Transgrid Reference Number: 2025-110

SSD Number: (SSD-5145-Mod-4)

Location: 100 Miller Road, Fassifern, NSW 2264

Proposal: Expansion of an existing coal stockpile on the boundary of Transgrid's Easement. From 100,000 Tonnes to 400,000 Tonnes.

Drawing Title	SITE LAYOUT PLAN	Size	A3
Drawing No.	12609381-GHD-00-00-DRG-CI-00010	Rev	F

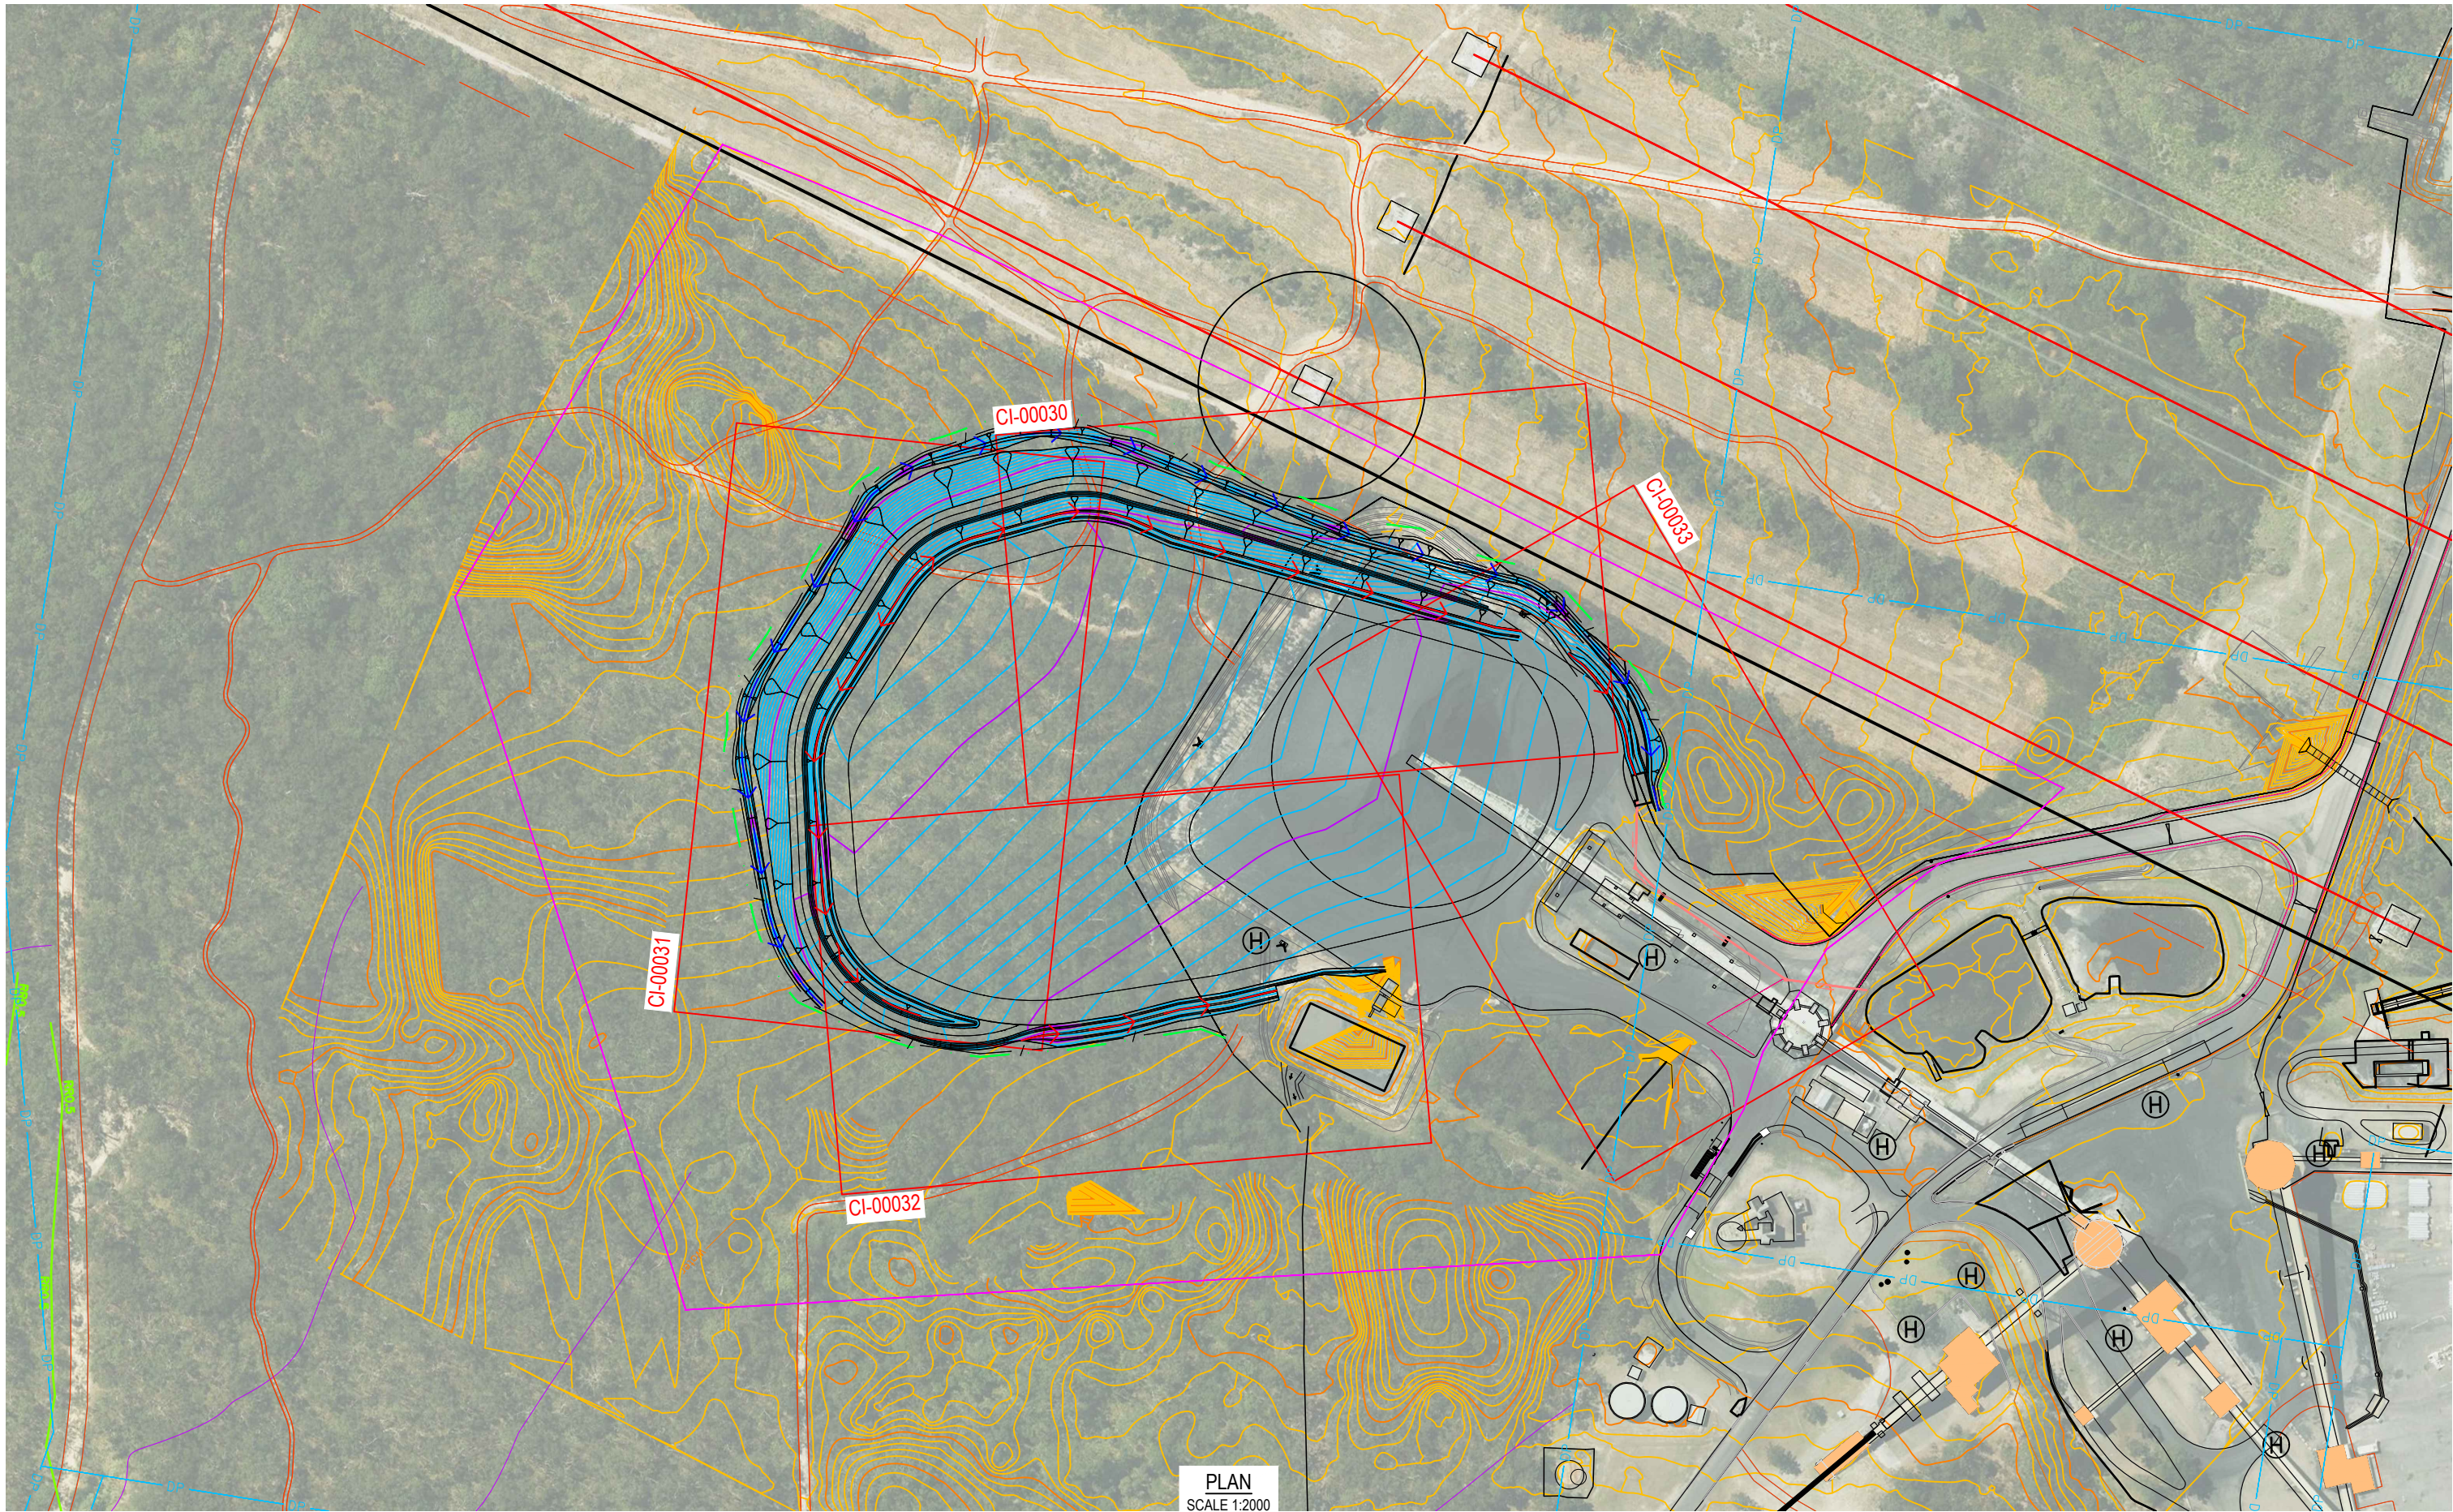
1. A portion of the current stockpile extending north-eastward encroaches the Transgrid easement and is close to the centreline exclusion zone
2. Coal stockpiles may tend to create dust that will affect the electrical performance of the transmission line.
3. The existing Transgrid access track will be affected by the proposed stockpile extension towards the west.

1. For the stockpile extension on the northeastern side of the existing stockpile, Transgrid requires a georeferenced 3D DXF for ground clearance review (note: .dgn and .dwg are unacceptable).
2. This dust mitigation program must be submitted to Transgrid for review. A dust management plan will ensure that dust and dirt are not deposited on the transmission line conductors, insulators, or towers. Such deposits can cause a flashover or trip of the power lines.
3. Precautions must be taken to prevent damage to transmission line structures. Any damage caused by construction activities must immediately be reported to Transgrid.

1. Client proposes to modify the project boundary.
2. Access to Transgrid Structure 7D can be maintained from Structure 8D along electrical easement.

1. Client must not stockpile coal or any other material within Transgrid's easement.
2. All exclusion zones ie. 30 metres from tower and 17 metres from centre line, must be always maintained.
